TNT WAREHOUSE AND DISTRIBUTION CENTRE (SSD 6040)

RESPONSE TO SUBMISSIONS

A	DEVELOPMENT APPLICATION	21.08.13
B	ORANGE PRECAST PANELS ADDED ALONG NORTHERN ELEVATION	18.11.13

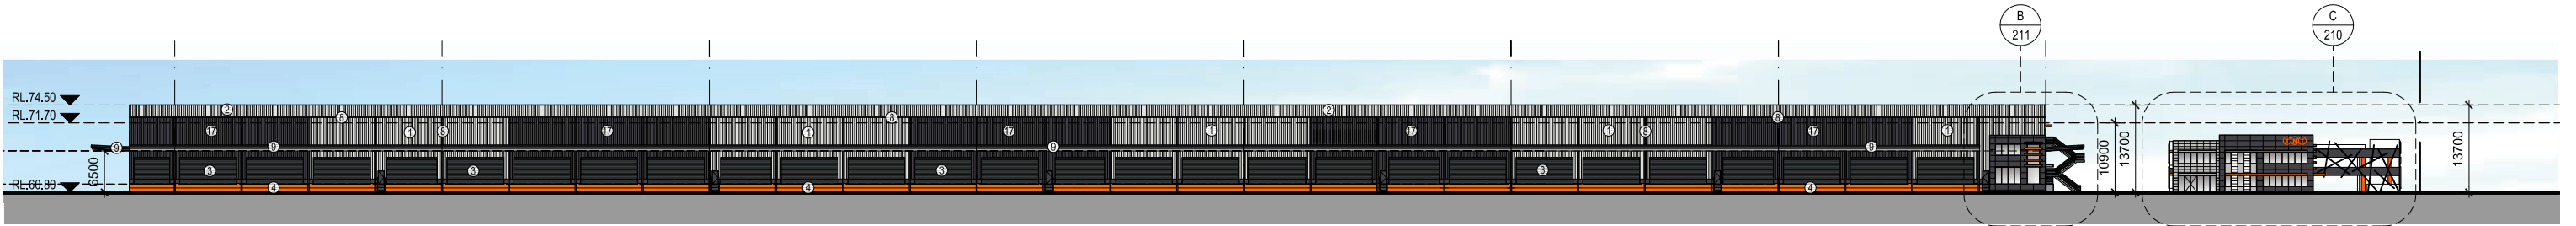
Penrith City Council	
<p>Architectural merit of the proposed building Consideration should be given to the design elements of the northern elevation of the building including:</p> <ul style="list-style-type: none"> • Breaking up the roof form; • Greater use of articulation and colour; and • Utilising exposed frames and oversized elements such as downpipes to create visual interest. 	<p>The northern elevation of the building has been improved by adding:</p> <ul style="list-style-type: none"> • Precast panels extending to the eaves line to breakup the roof form and geometry; • Additional colour to intersperse the corporate colour and help punctuate the wall panels; and • Oversized downpipes painted in contrasting colours to provide more contrast and visual interest. <p>Attachment 1(a) is revised drawing DA-002(B); Attachment 1(b) revised drawing DA 200(B); and Attachment 1(c) is a new drawing to the original DA set. This drawing DA 201(A) was added as the scale of the overall elevation was a little difficult to read at A3 size.</p>
